RE: **Reflective Auto Collision**  
**801 Gibson Blvd SE**  
**Grading Plan Stamp Date: 7/15/19**  
**Hydrology File: L14D061**

Based on the submittal received on 7/16/19, the grading plan cannot be approved until the following corrections are made:

ENGINEER'S CERTIFICATION-JAN.-2025

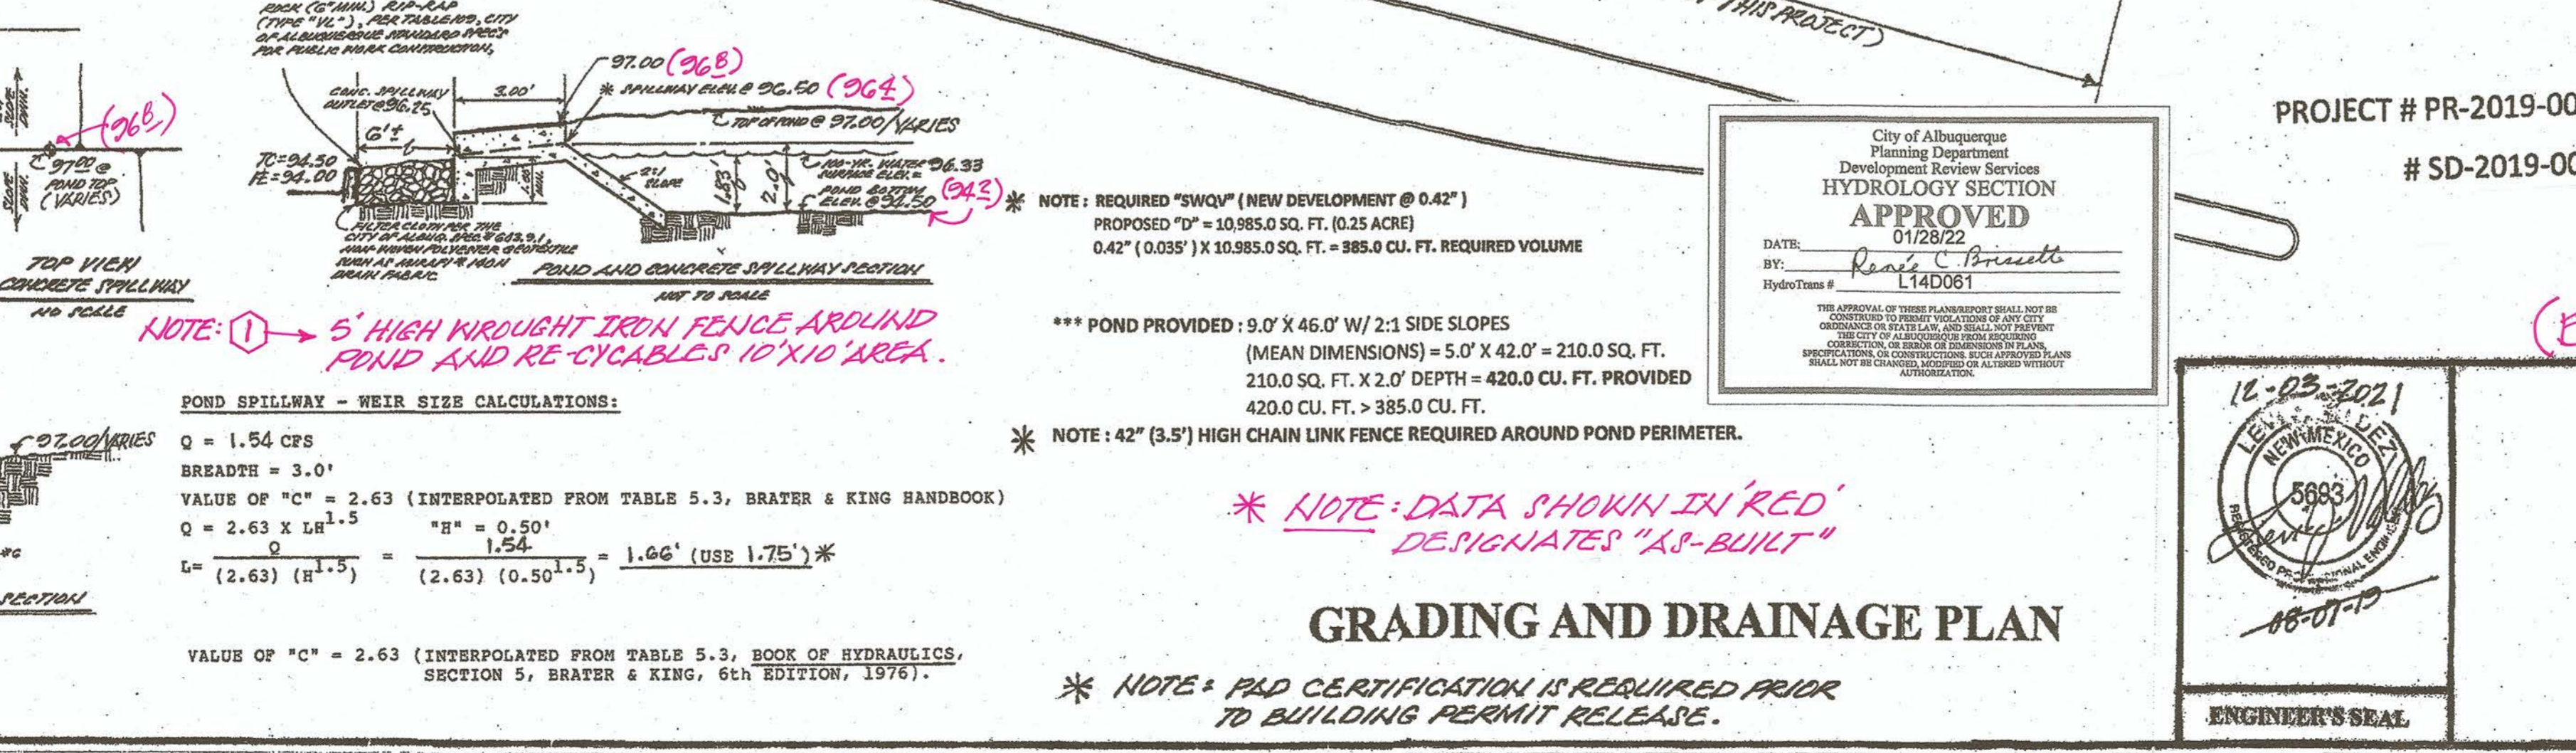
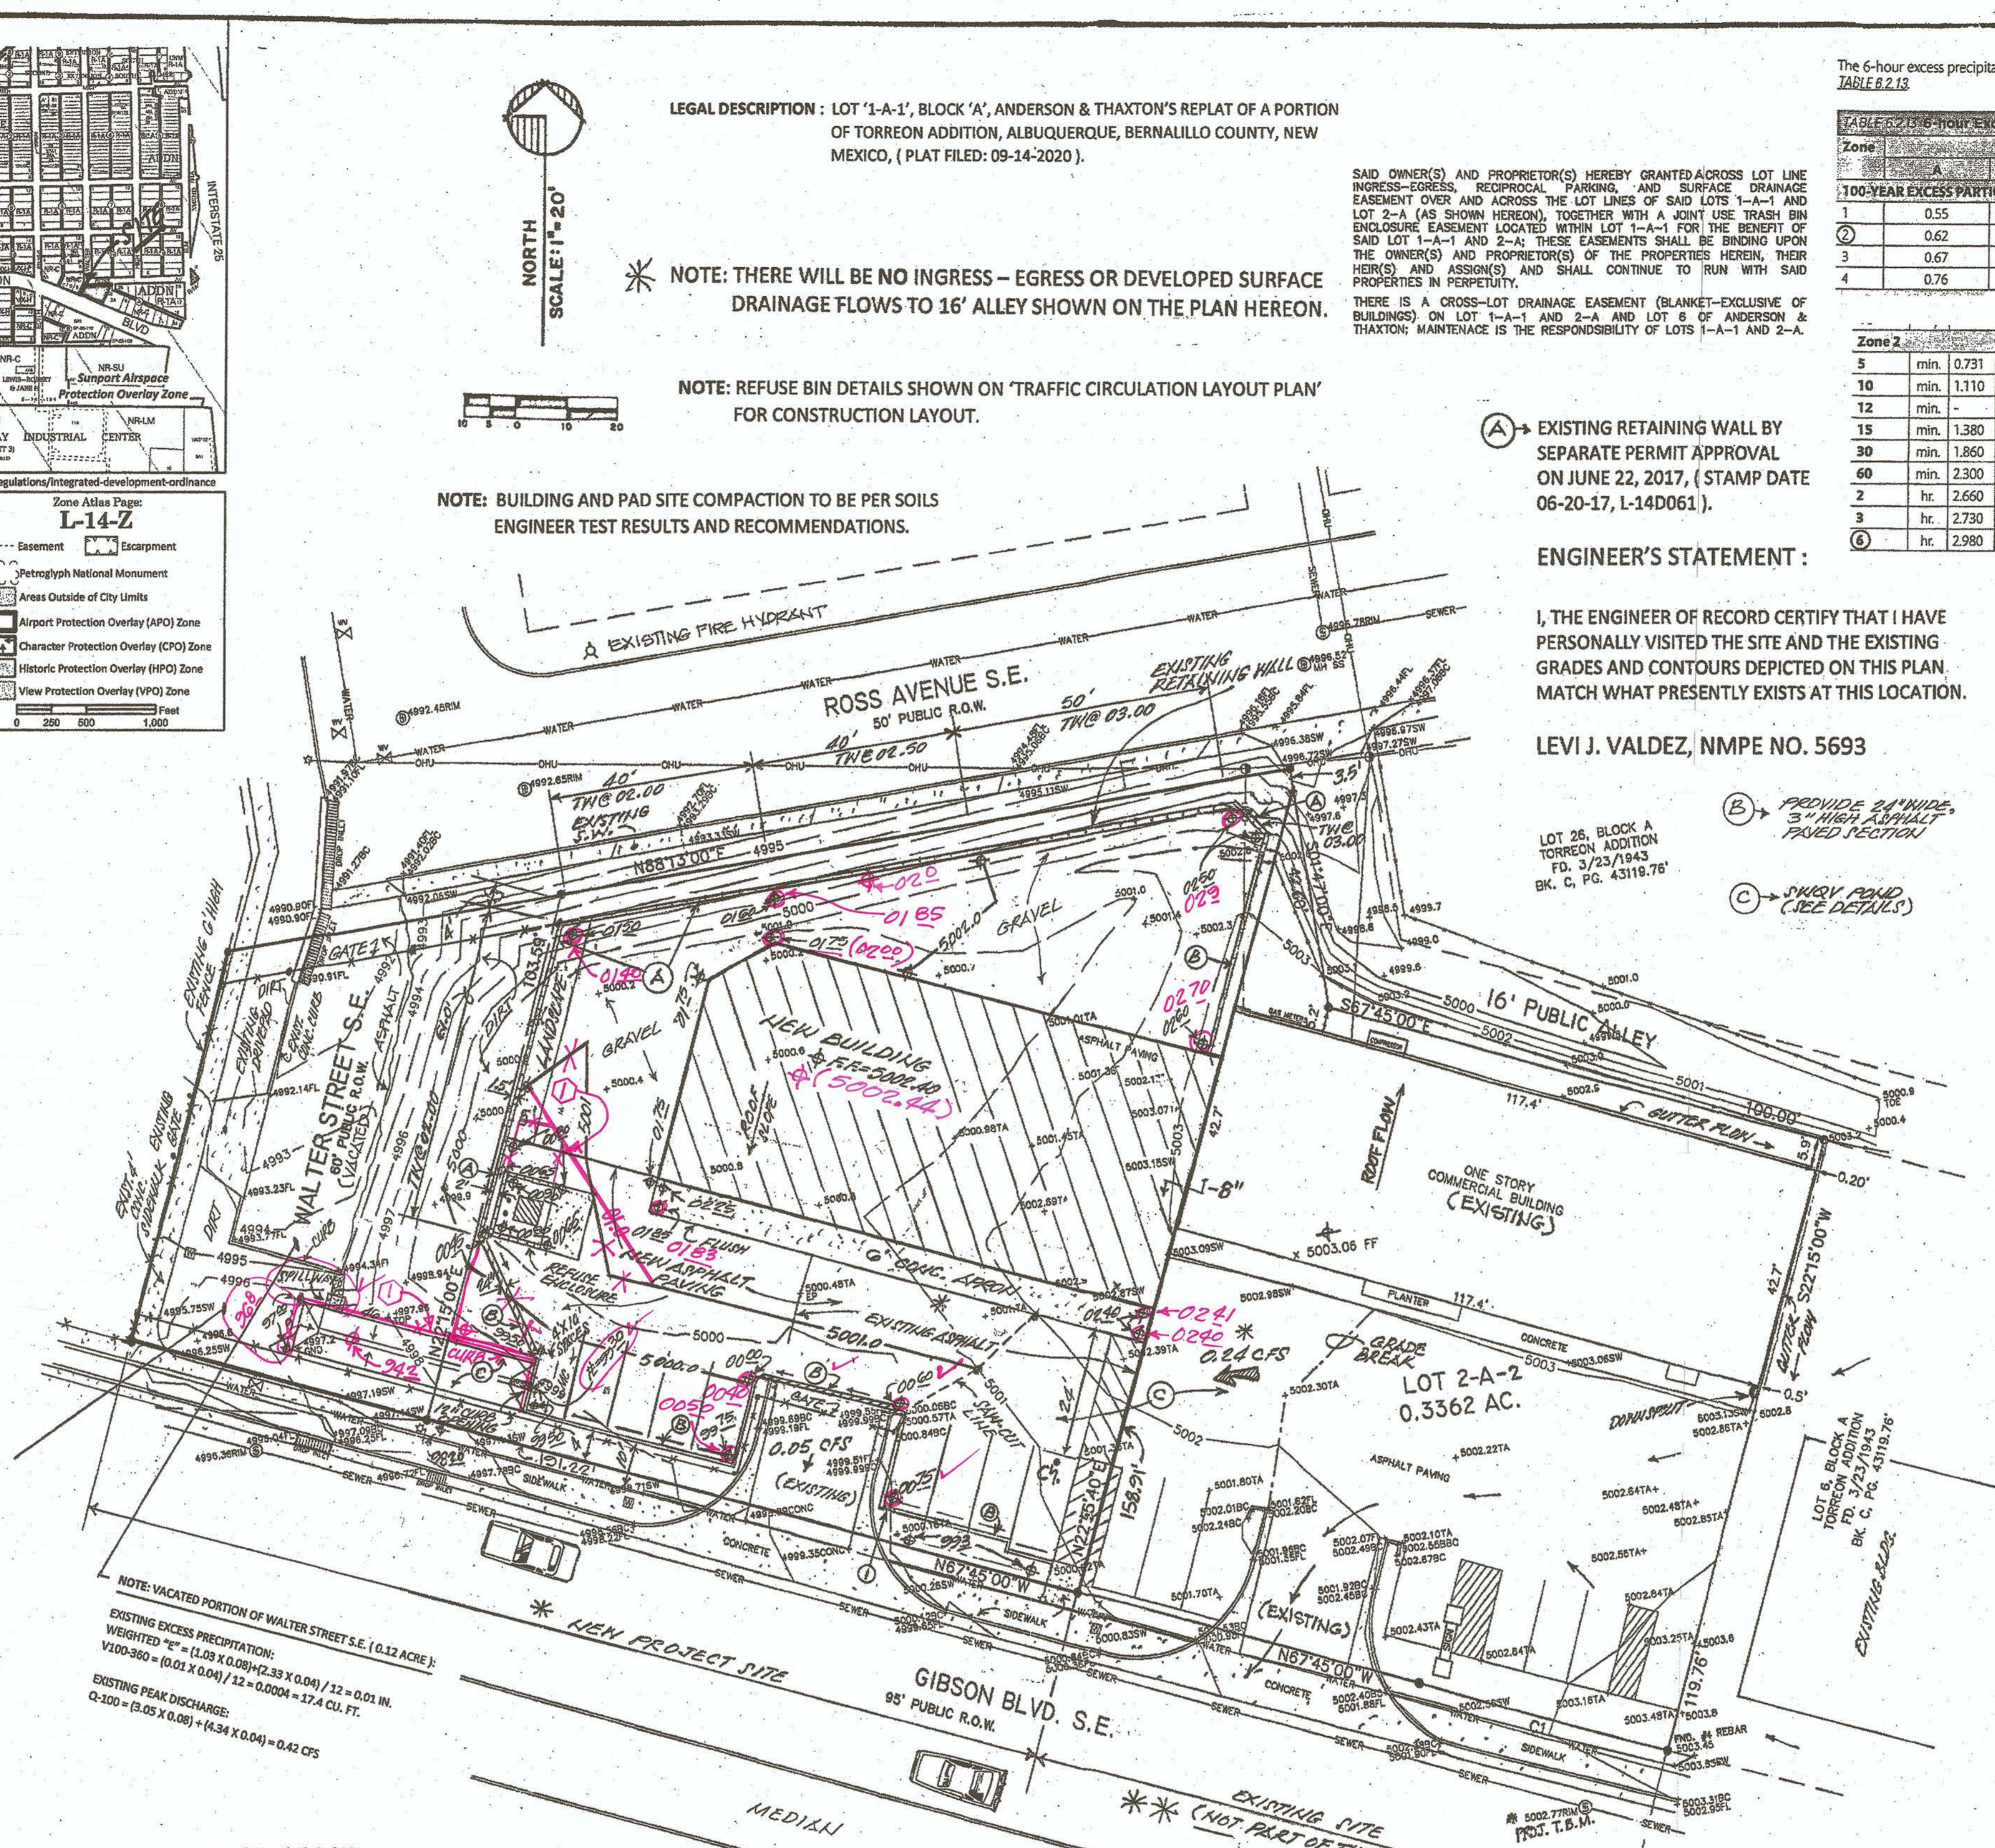
4. The grading and drainage plan must identify and quantify all offsite flows as they pertain to these two parcels and their frontage.
5. Show the frontage improvements for any drainage infrastructure identified. All frontage improvements must be designed to current City standards.

6. Provide an armored conveyance (concrete or asphalt) to allow storm water to drain into the inlets at Walter and Ross Street.
7. Identify flow and flow bypass in the 16' alley. Any flow that bypasses the angled inlet in the alley needs to be conveyed to Ross on an armored surface.

8. The grading and drainage plan must identify and quantify all onsite flows, existing and proposed, as they pertain to these two parcels; information is missing for Lot 2-A-2.

9. The site must demonstrate adequate downstream capacity per § 14-5-2-12(G) of the Albuquerque Code of Ordinances.

10. Provide the weir calculations, per DPM Chapter 22.3.A.1, for the curb cuts. A coefficient of 2.7 is typically used for the weir equation  $Q = CLH^{2/3}$ .
11. How will the pond discharge to the public ROW?
12. The as-built size of the retaining wall does not appear to match you plan; please confirm and correct the limits of the new retaining wall.
13. Provide a waterblock on the Gibson entrance to ensure onsite flows are routed into the Stormwater Quality (SWQ) pond.
14. Label the pond with the SWQV and elevation, the 100-year volume and elevation, the peak 100 year inflow and outflow, the spillway crest elevation, and the spillway flow depth.
15. For automotive repair centers, demonstrate *control of oil from vehicle parking areas* per DPM Chapter 22.9.E, Table 1.
